SSD-50587460 – Panorama BESS, TfNSW advice on Response to Submissions and Amendment Report

Transport for NSW (TfNSW) is responding to the Response to Submissions (RtS) and amendment report referred via the Major Projects Portal. TfNSW has reviewed the additional information prepared by the proponent, including the updated Traffic Impact Assessment prepared by NGH, revision 3.2, dated 17 April 2025, as key documents for preparing this response.

SSD-50587460 – Panorama BESS, TfNSW Advice on Amendment Report, Bathurst Local Government Area

RIGHT TURN
Lachlan Valley Way &
Mid Western Hwy

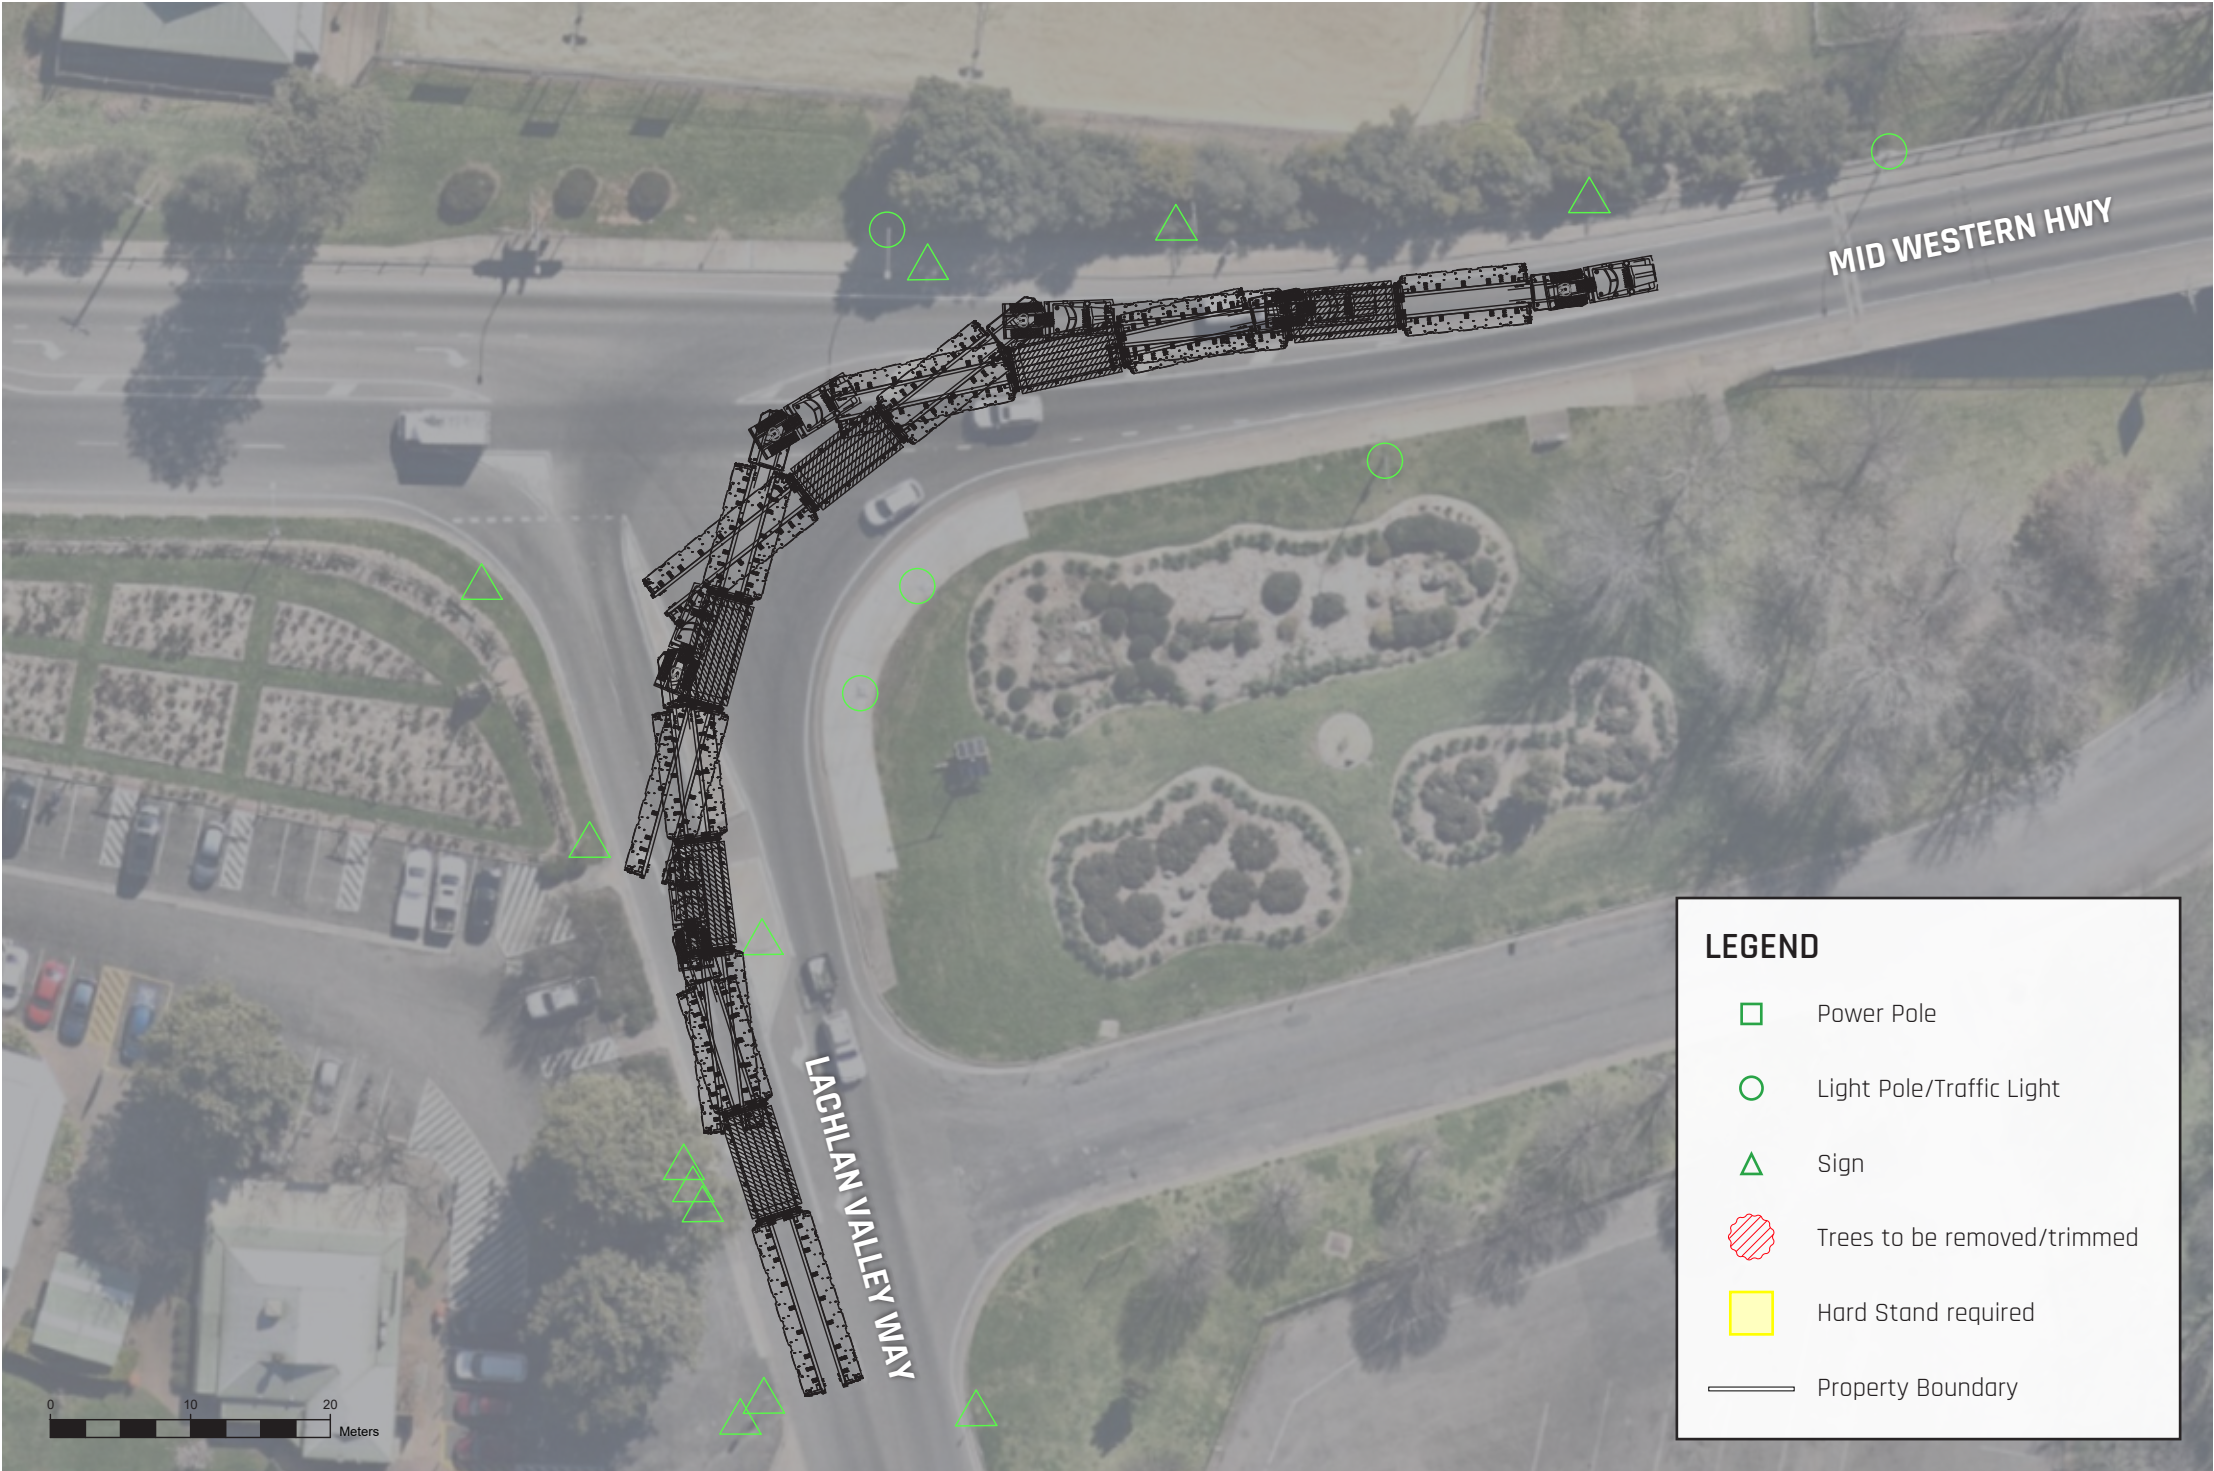
<p>-Roundabout on Lachlan Valley Way is shown to be impacted by the vehicle swept path as well as the medians either side of the roundabout at the locations of the sign removal.</p> <p>-The corner of Mid Western Highway and Lachlan Valley requires further investigation. If the existing pavement is not suitable, the proponent will need to provide strategic designs of the median that identify the scope of work required to strengthen the pavement of the median(s). Strategic concept designs are required for any identified works, see advisory notes.</p> <p><i>Note: core log samples will need to be taken as part of this investigation, which will require a s138 Roads Act approval and ROL.</i></p>
	<ul style="list-style-type: none"> Identify and assess implications of any road and rail projects that may be under construction during the indicative schedule for the OSOM movements. <p>Note: NHVR permits do not cover road works or upgrades and environmental approvals required for proposed OSOM route(s). Any road works or upgrades works required along the OSOM route must be included within scope of works in the SSD to ensure constructability.</p> <p>Note: Given high number of renewable energy and other large scale projects requiring haulage of OSOM components on the road network, restrictions and limitations on OSOM movements may be imposed. In this regard, it is recommended you engage early with</p>	<p>CLOSED – proponent has identified the Mt Ousley upgrade project. Proponent is to make contact with the team prior to movements occurring to ensure. This should be done prior to determination of the consent to ensure the proponent has considered all impacts.</p> <p>Regarding rail, The OSOM Route Study identifies two railway level crossings on CRN rail corridors along the proposed OSOM route:</p> <ul style="list-style-type: none"> Mid Western Hwy, Cowra (Blayney to Cowra non-operational CRN corridor) Adelaide St (Mid Western Hwy), Blayney (Taranga to Orange Junction Operational CRN corridor) <p>The proponent must note, if required to traverse UGLRL-managed assets or infrastructure, including level crossings for OSOM/heavy</p>

Appendix H Strategic Design Drawings and Swept Path Assessments

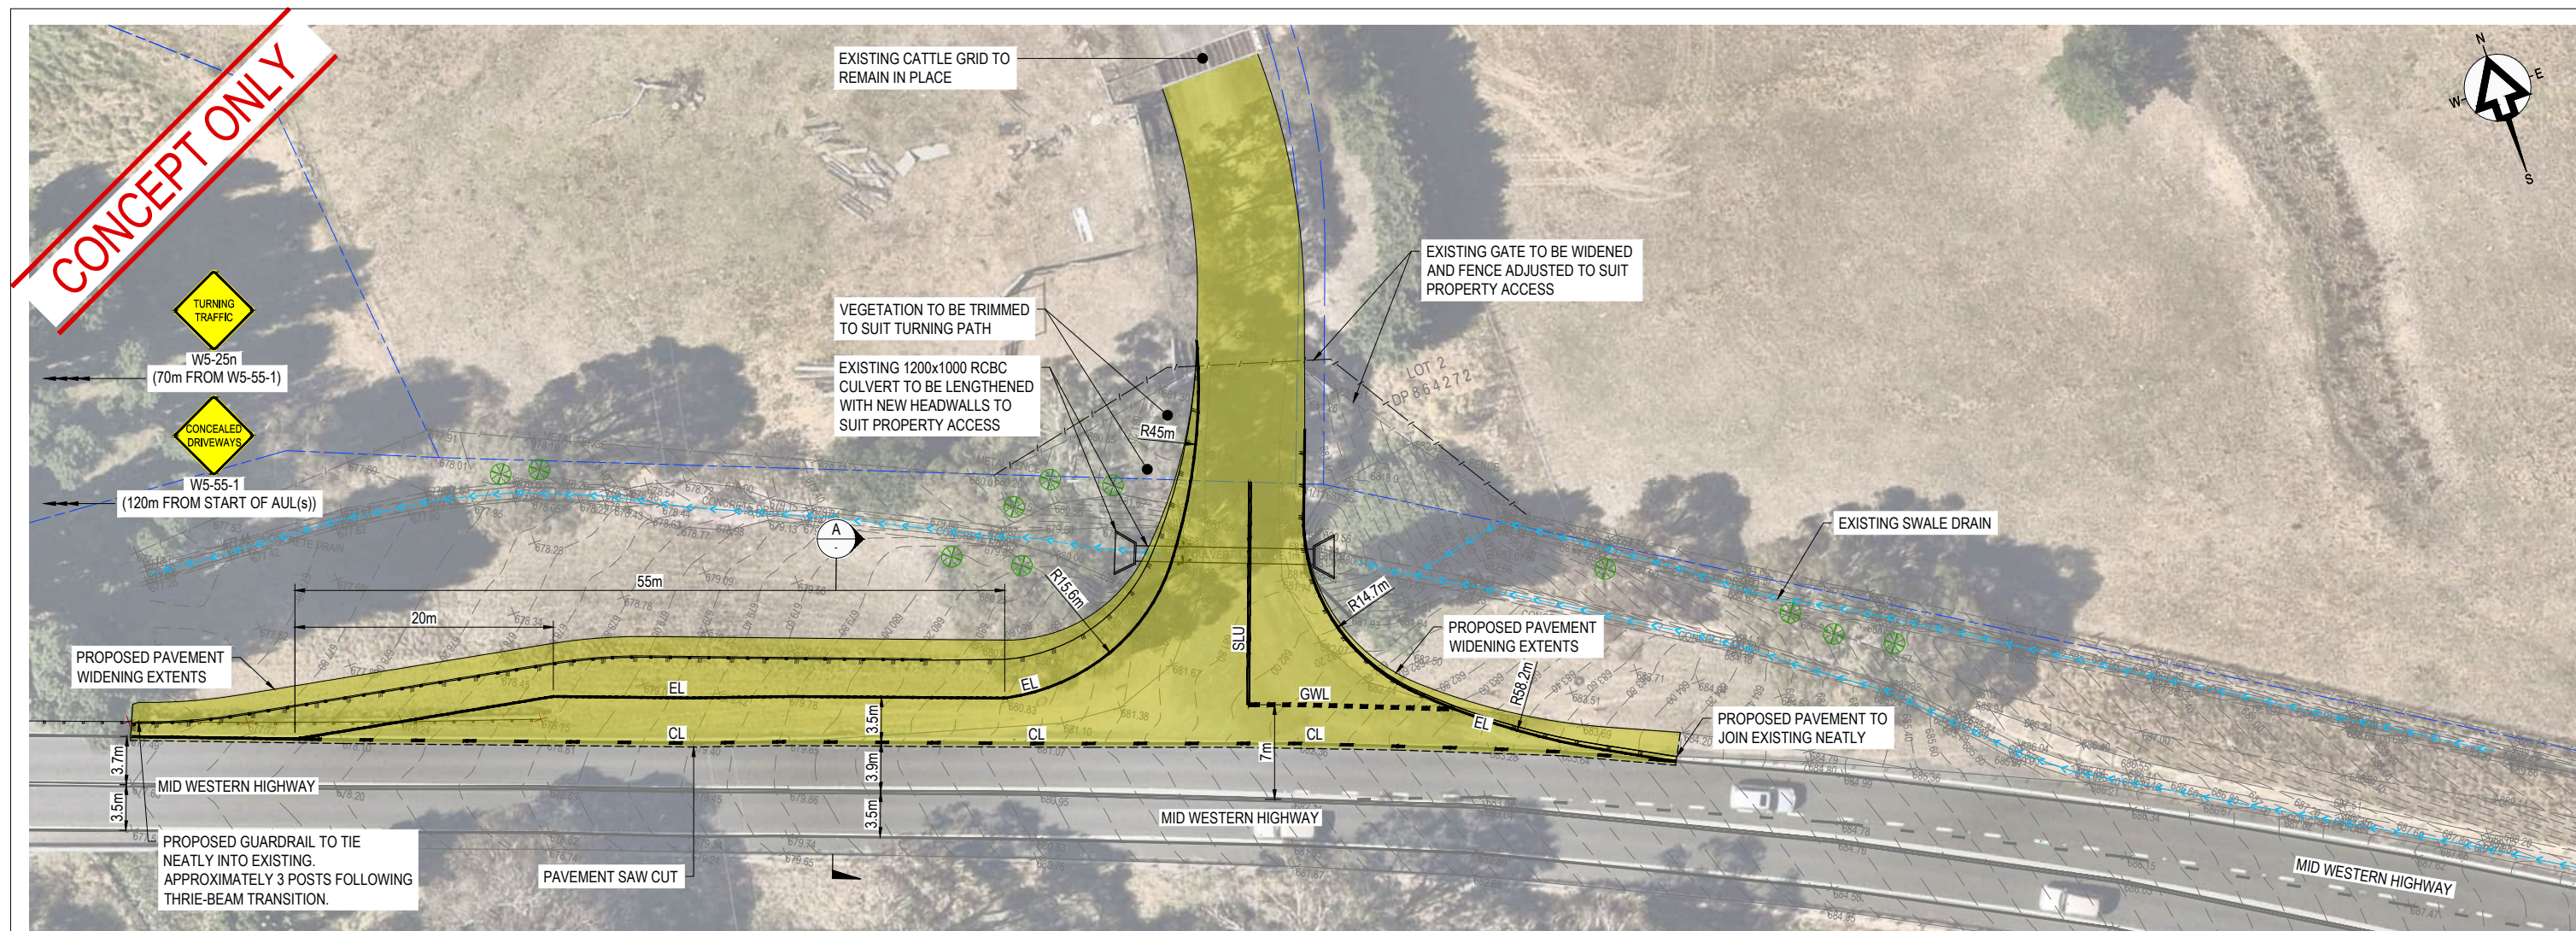
<p>8.</p>	<p>Strategic Designs</p> <p>TfNSW is not able to assess the suitability of the proposed site access due to lack of suitable information. Any road upgrades along state classified roads are to be accompanied by Strategic Designs, prepared in accordance with TfNSW Strategic Design Requirements for DAs Strategic design requirements for DAs - February 2022 (nsw.gov.au)</p> <p>In addition to these requirements the Strategic Designs will need to be accompanied by revised swept paths for the design vehicle and OSOM vehicle entering the site and accessing the intersection of Mitchell Highway and Evans Plains Road. The swept paths must demonstrate the design vehicle can turn concurrently in all directions without crossing into the incorrect lane,</p>	<p>OPEN – The provided strategic designs are still deficient. The designs do not achieve the minimum requirements as per TfNSW strategic design fact sheet. Please ensure all plans are dimensioned. Further issues with strategic designs are detailed in the points following.</p>

11.	Updated plans are required to clearly show site boundary and road reserve based on a survey.	OPEN – The proponent has identified the property boundary of the Strategic Concept Designs. Works for the intersection are shown to be located within the road reserve and the subject property of the application however it is not clear this is based on a survey as required by point 11 of the previous letter. The strategic concept designs are to be updated to identify the cadastral boundaries of the road reserve and subject property.
